Application number: 2026/92032	
What is the application for?:	Non material amendment to previous permission 2024/92647 for erection of detache
Address of the site or building:	Land at, Occupation Lane, Off Birkby Road, Huddersfield, HD2 2ES
Postcode:	HD3 4EY

Drawing title
Garage Floor Plan and Elevations as Proposed

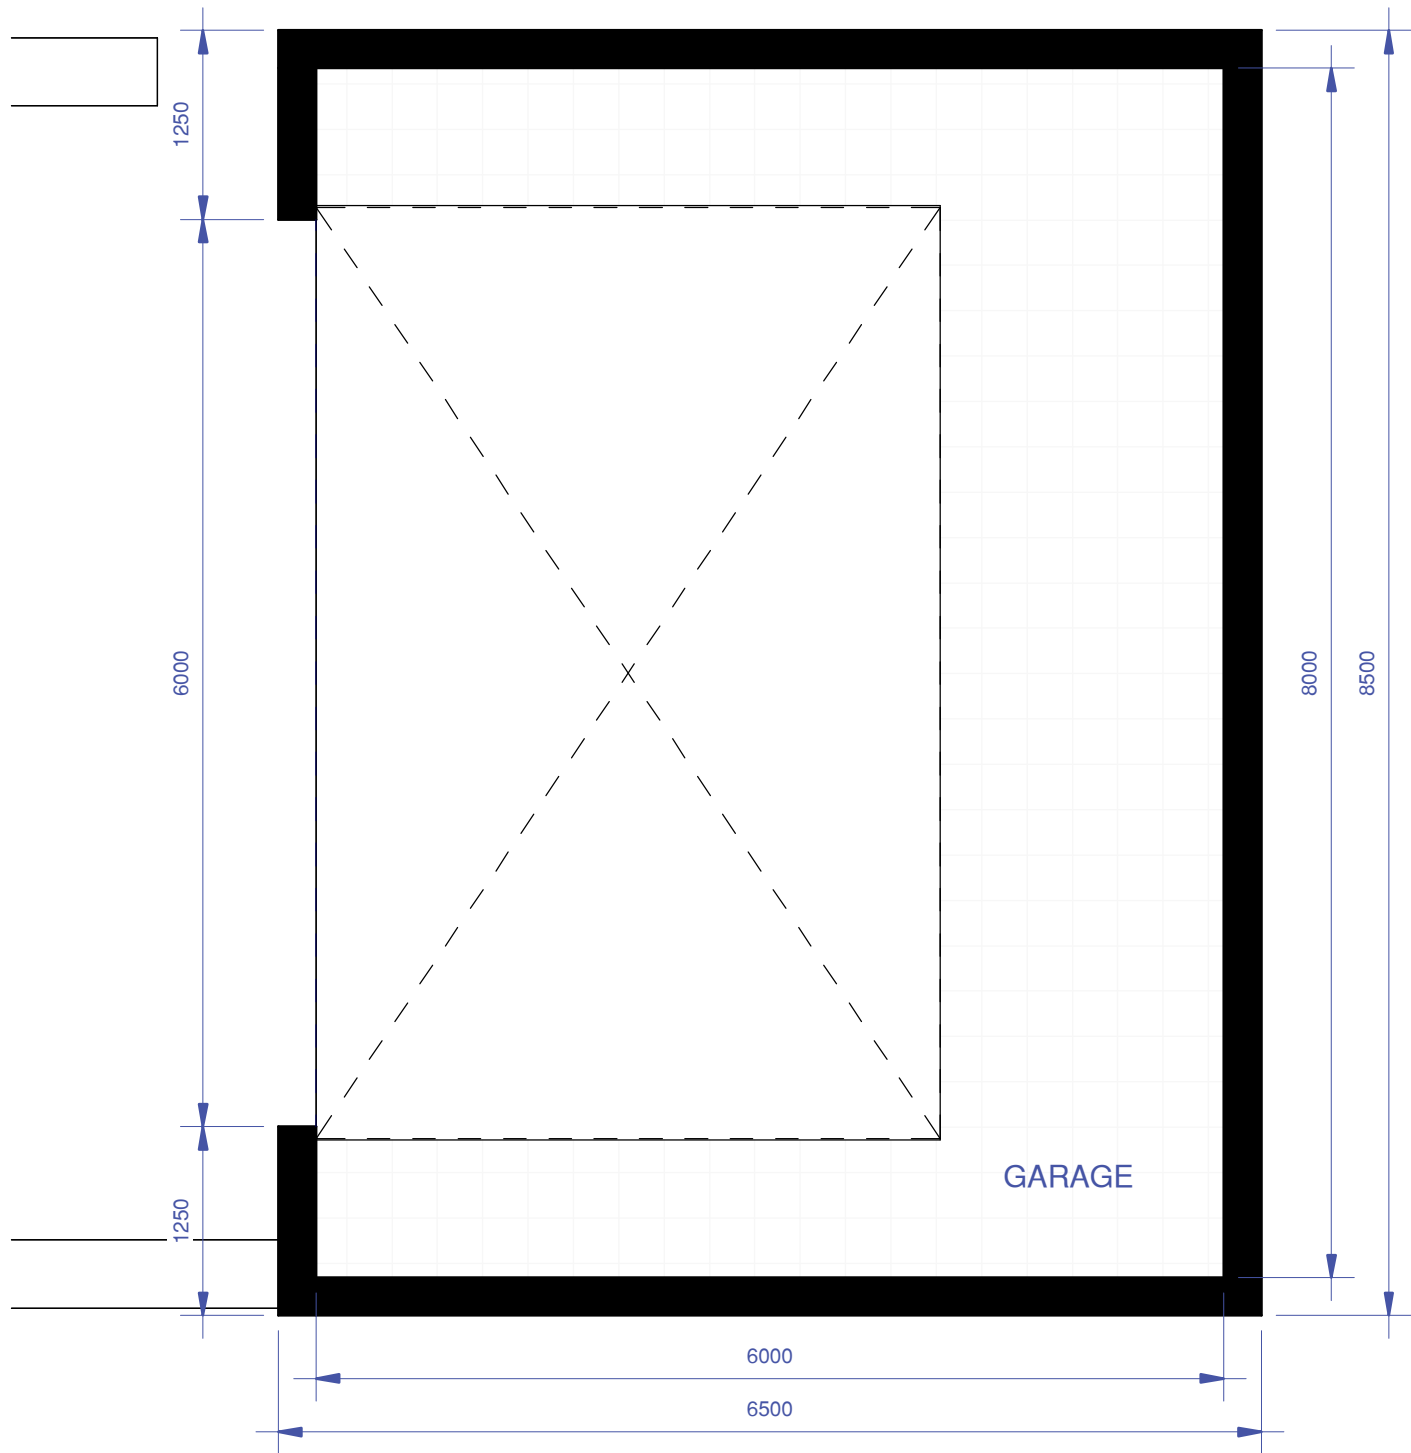
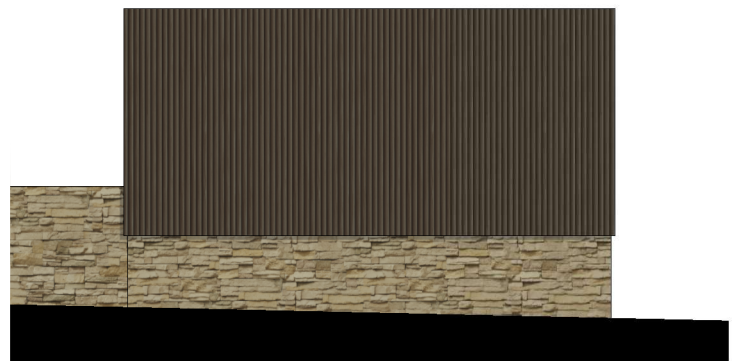
As the dwelling and garage are now repositioned and enlarged, it cannot be confirmed whether these specific safeguards – particularly separation distances and privacy mitigation – remain as originally approved. This should be reassessed against the amended plans rather than relying on conclusions reached for the original permission.

confirms the revised separation distances to neighbouring properties and that all existing planning conditions continue to apply;

SITE PLAN AS PROPOSED
SCALE 1:200

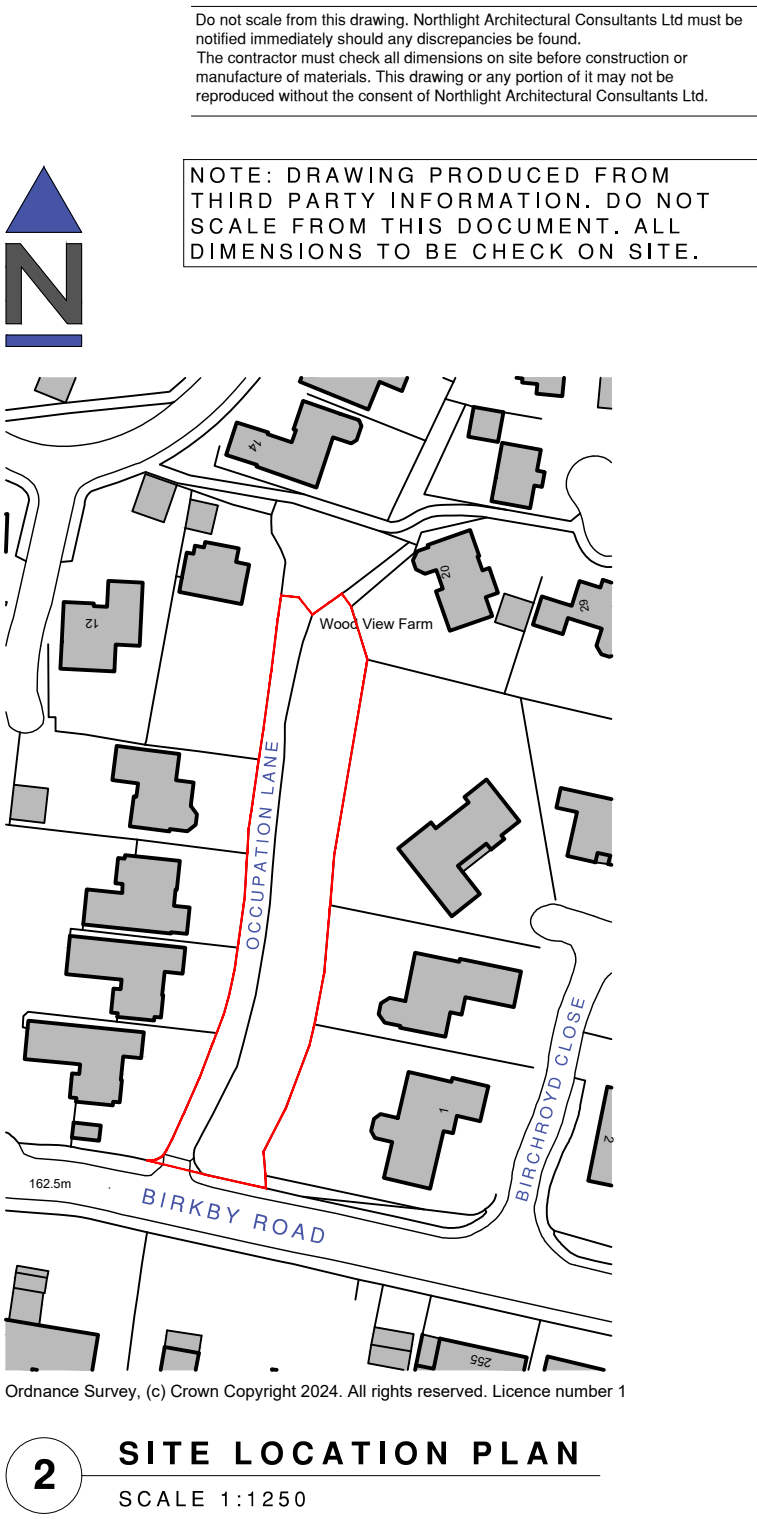
The application does not provide sufficient information for neighbouring residents or the Council to properly assess the proposed amendments. No cross-sections or levels information has been provided to demonstrate whether finished ground levels, finished floor levels or retaining structures have changed from those previously approved.

requires levels drawings and cross-sections showing existing and proposed ground and finished floor levels; and

requires a drainage/services plan showing the location of any pipework close to the shared boundary.
